CITY OF ALBUQUERQUE

October 24, 2018

**Re: Mesa Del Sol Montage Unit 3B
Grading and Drainage Plan Engineer's Stamp dated: 8/29/2018, Drainage
Report Engineer's Stamp dated 4/25/2014 (R16D006)**

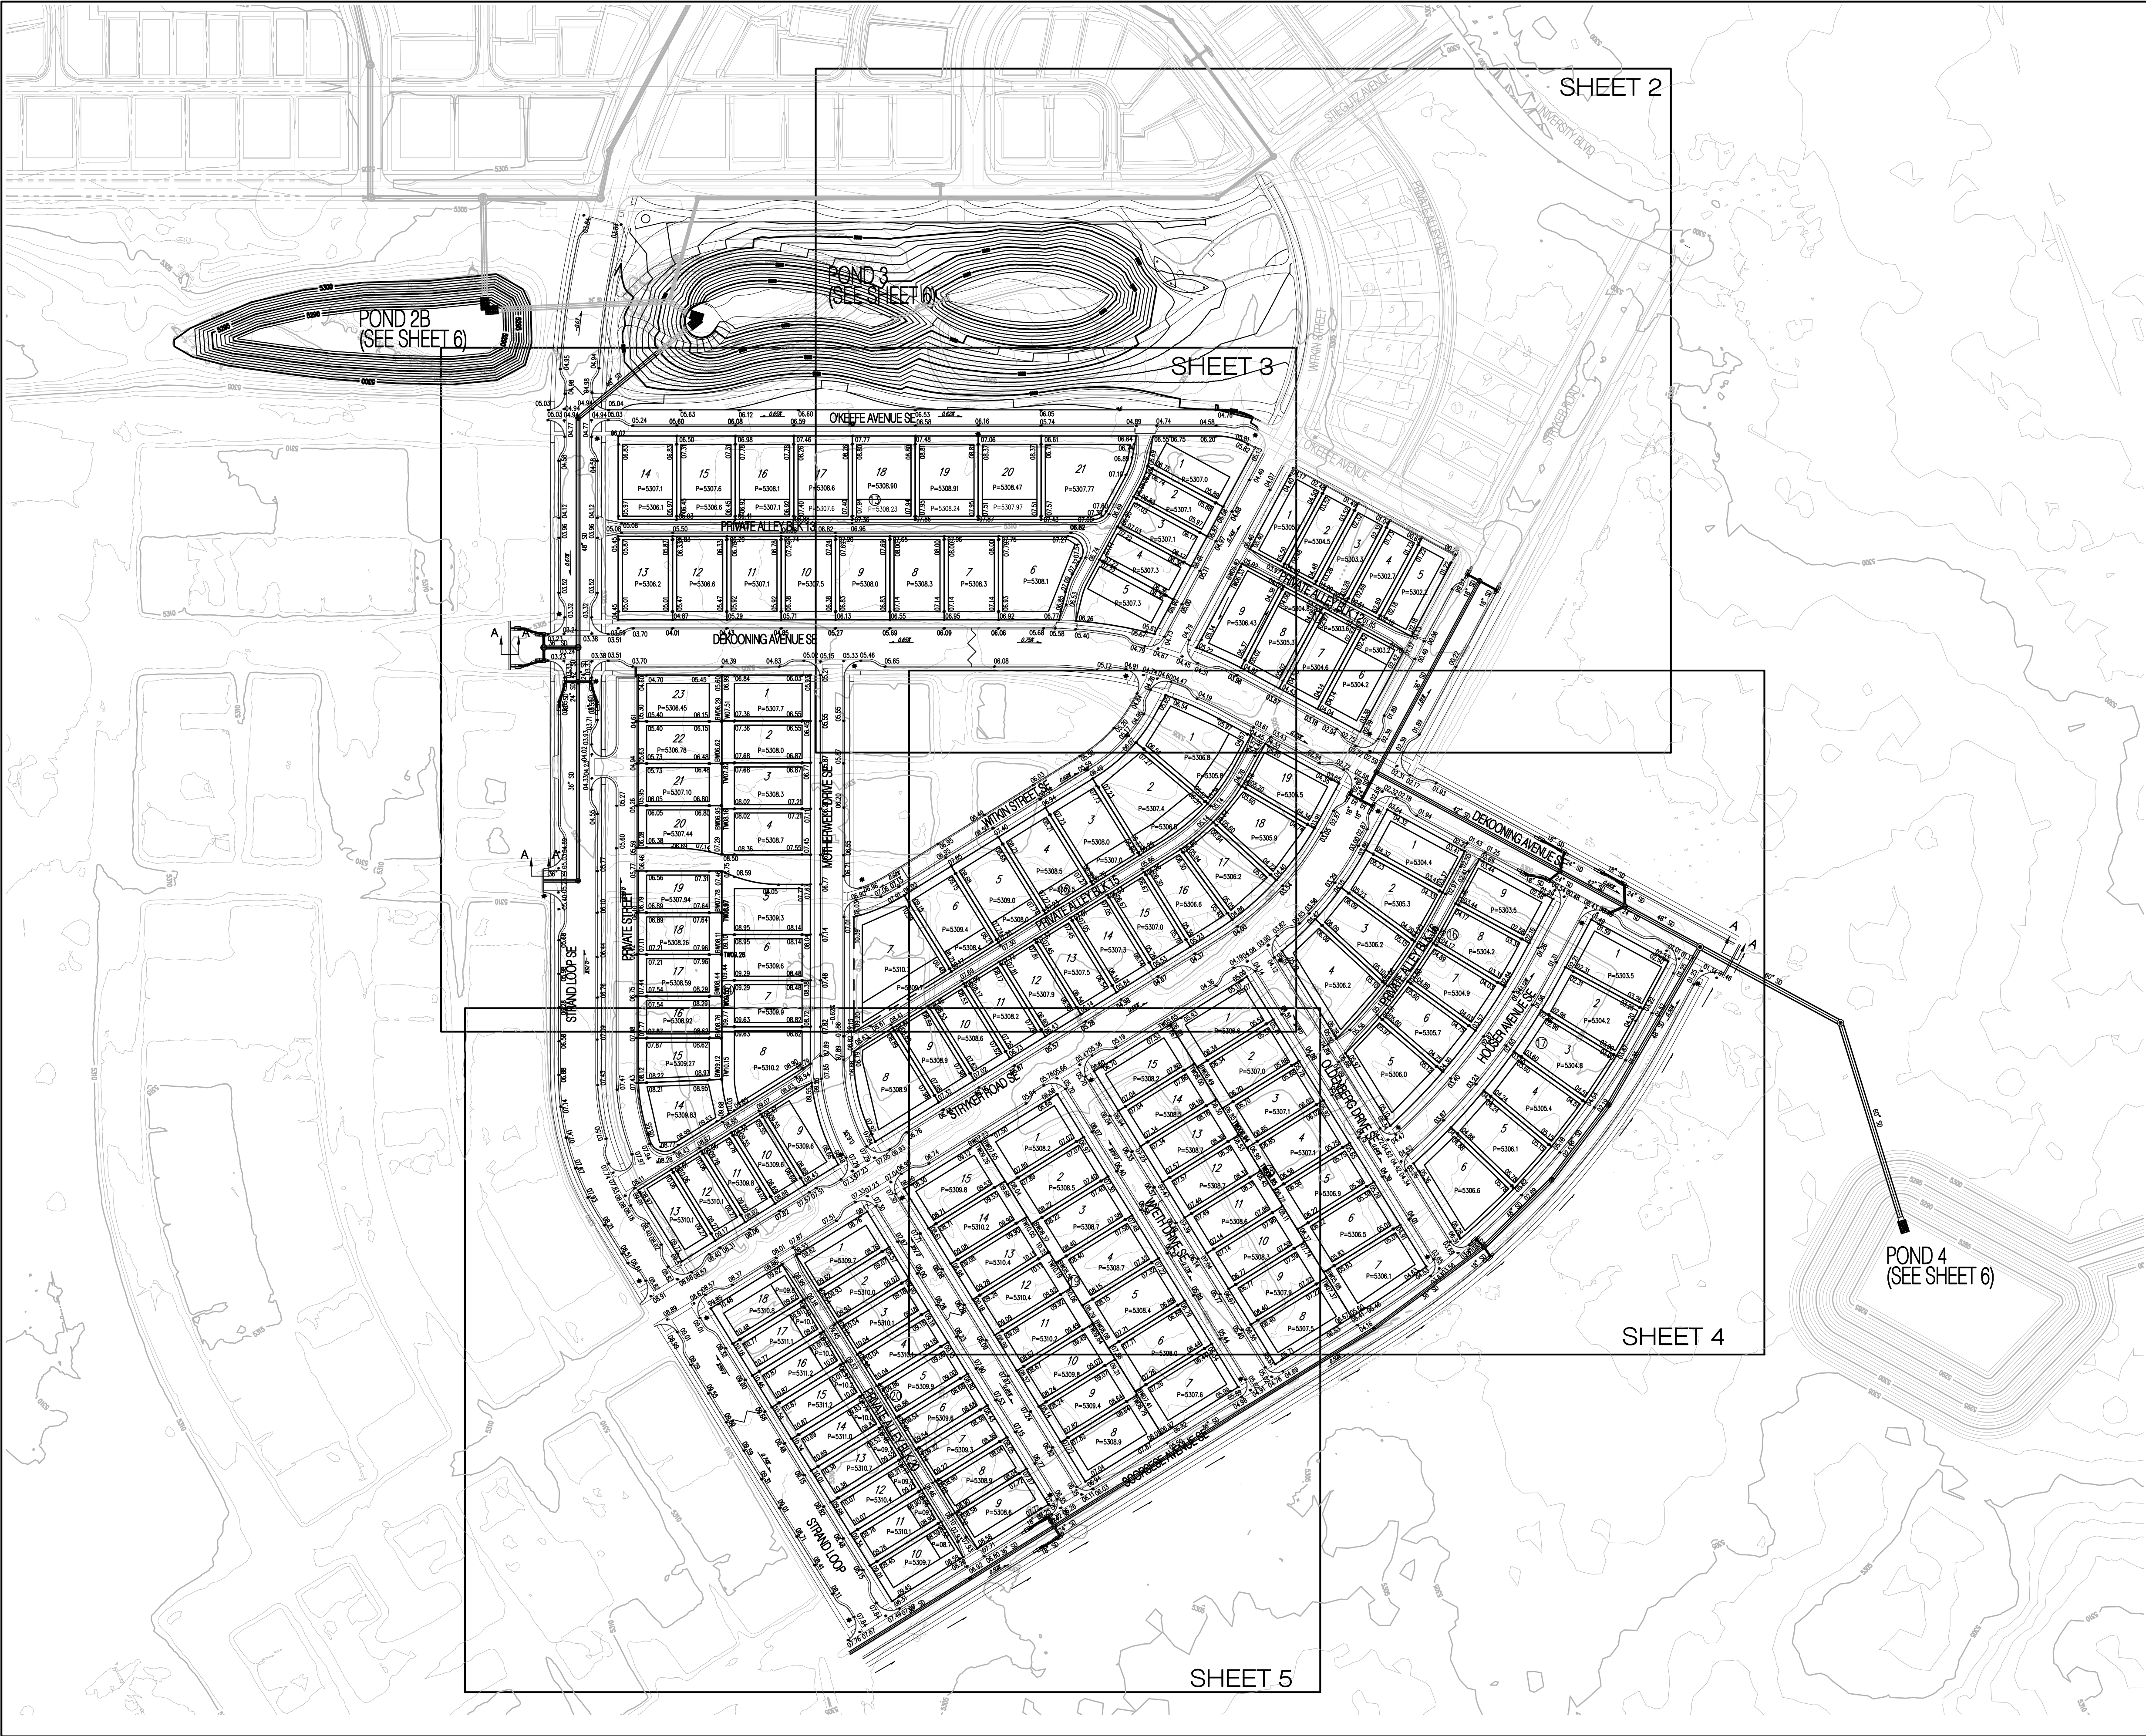
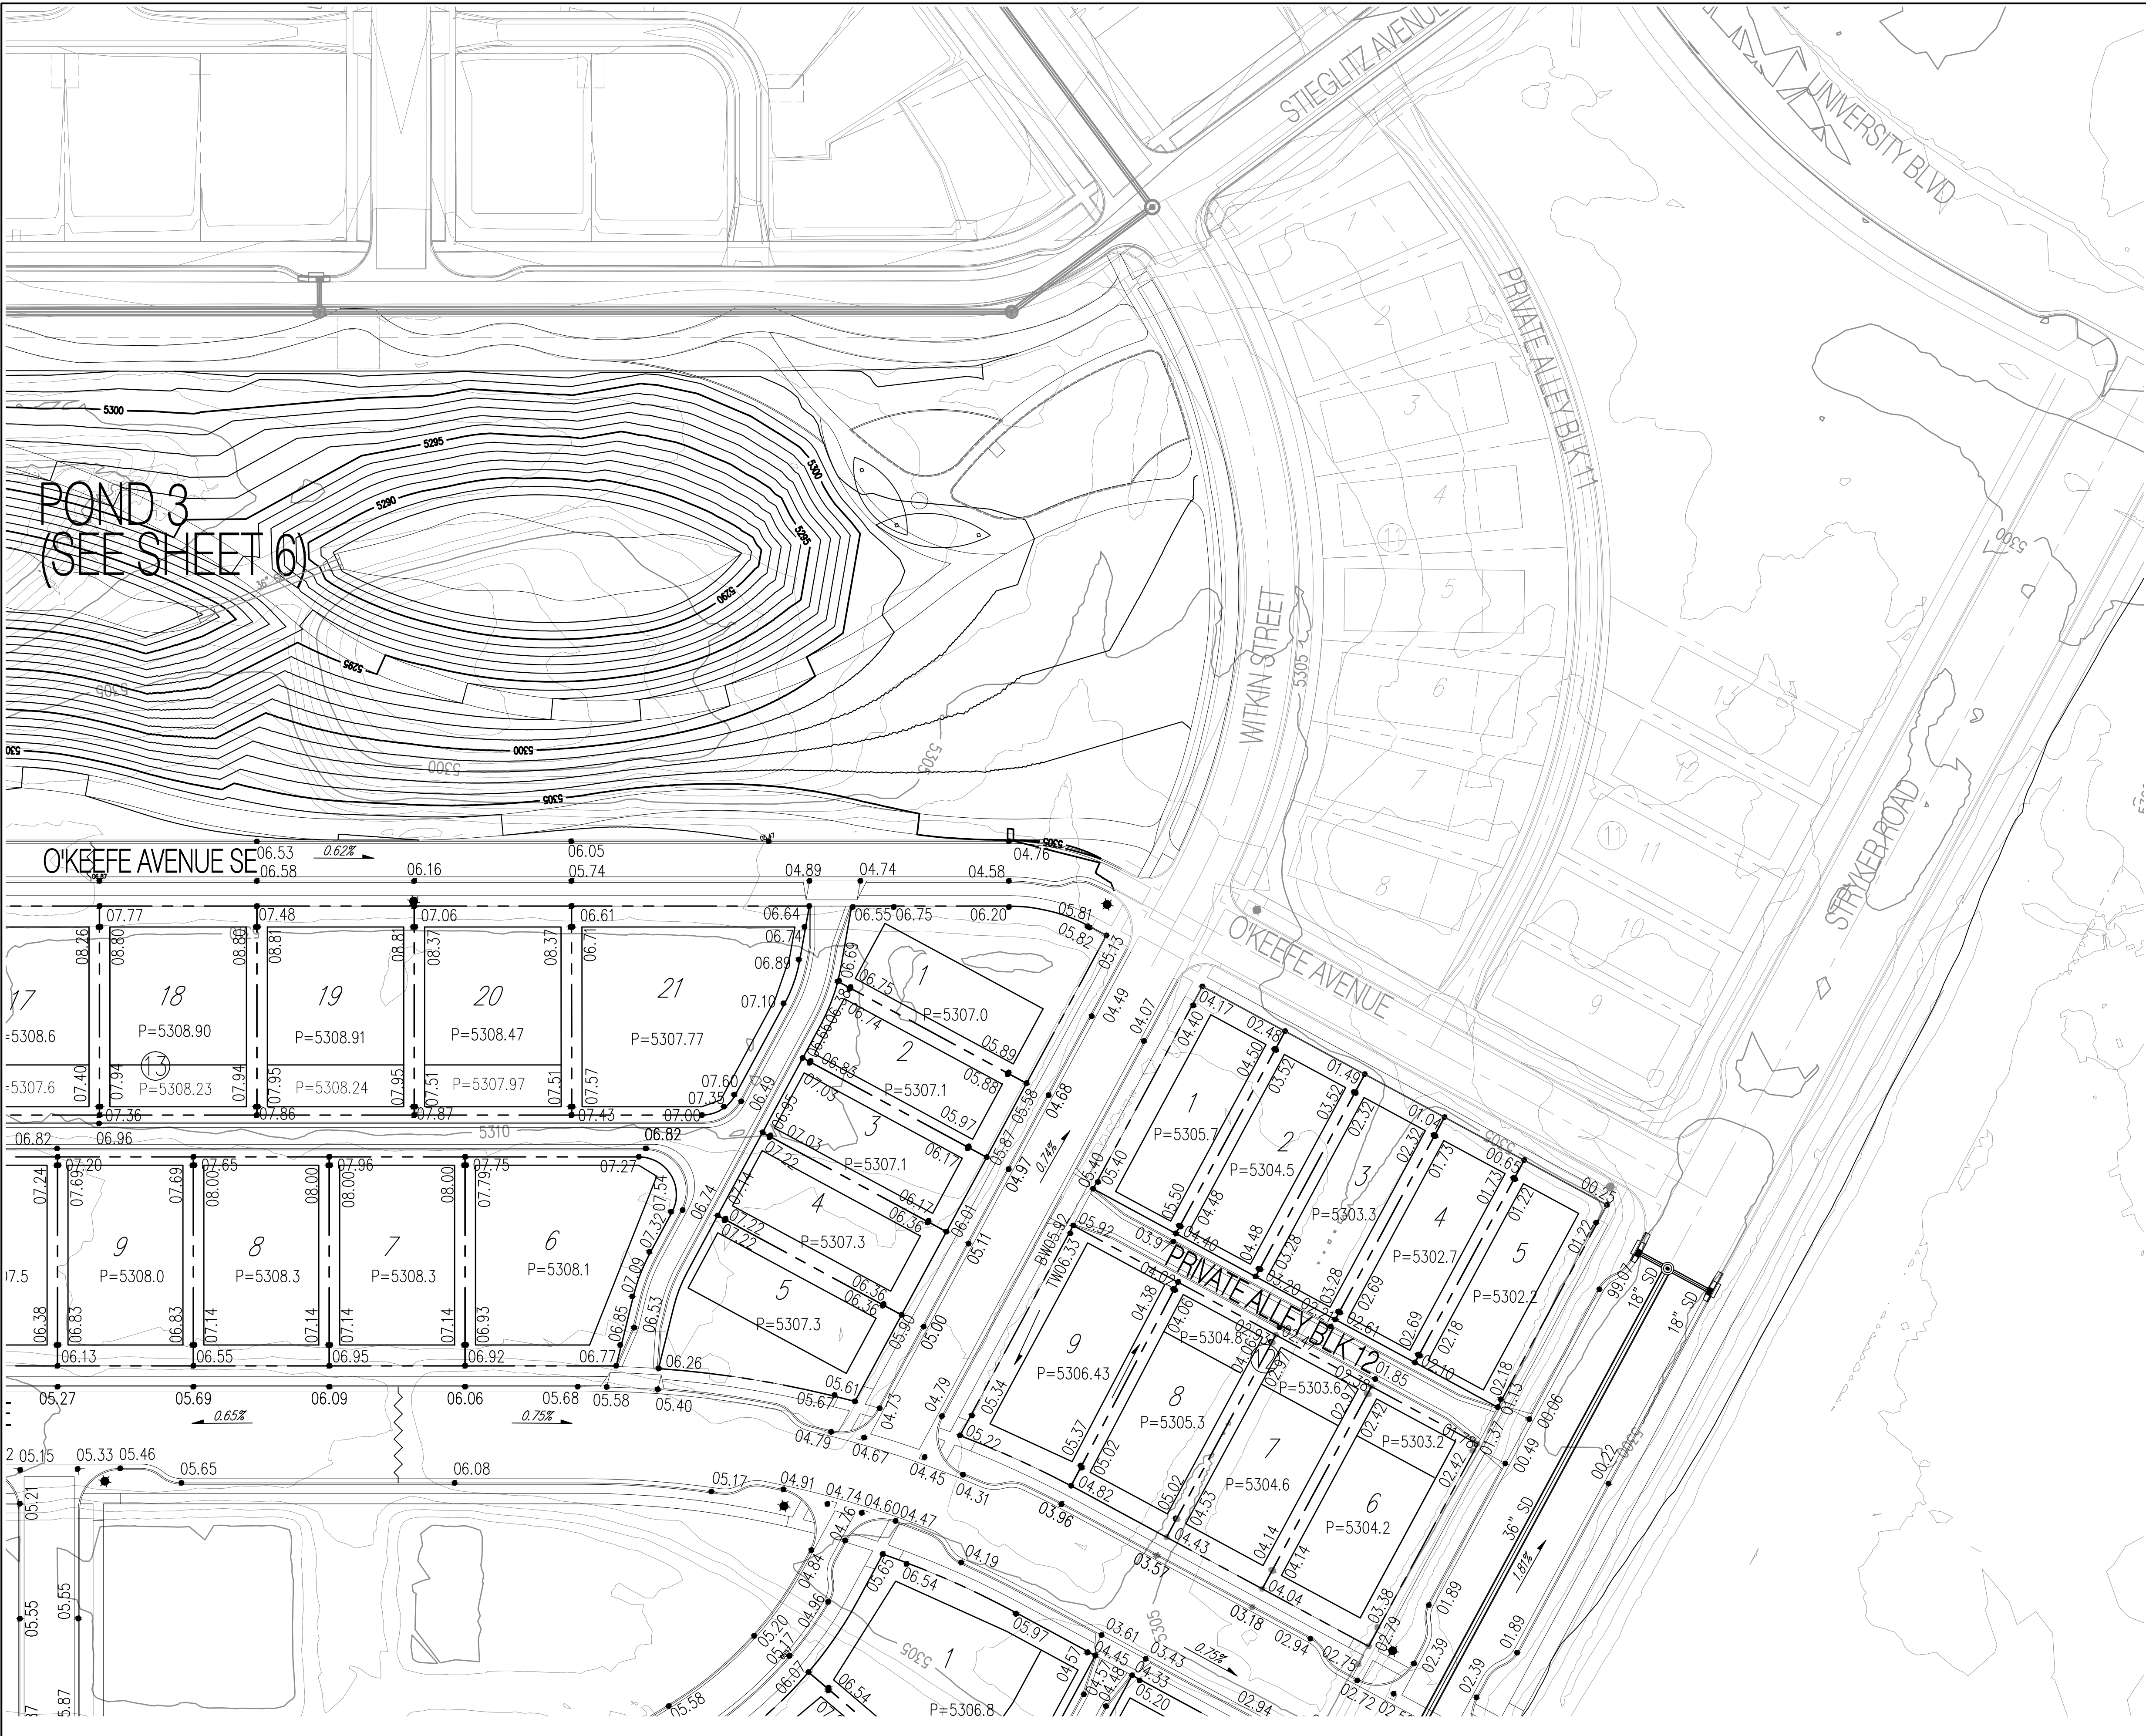
11. Several spot elevations on sheet 2 appear to be incongruous with the surrounding elevations:
 - a. Elevation 07.22 on the south side of Lot 5 Block 13 is 18" higher than the adjacent lot and street grades.

- b. Elevation 04.97 on the west corner of Lot 9 Block 12 is about half of a foot low relative to the adjacent street grades
 - c. Elevation 04.01 on the east corner of Lot 6 Block 12 is 3.5' higher than the adjacent street.

- d. Elevation 01.64 on the south corner of Lot 6 Block 12 is 18" lower than the adjacent lot and street grades.
 - e. Elevation 05.58 on the east corner of Lot 1 Block 15 is one foot too high relative to the adjacent lot and street grades.

All of the sheets need to be checked and fixed.
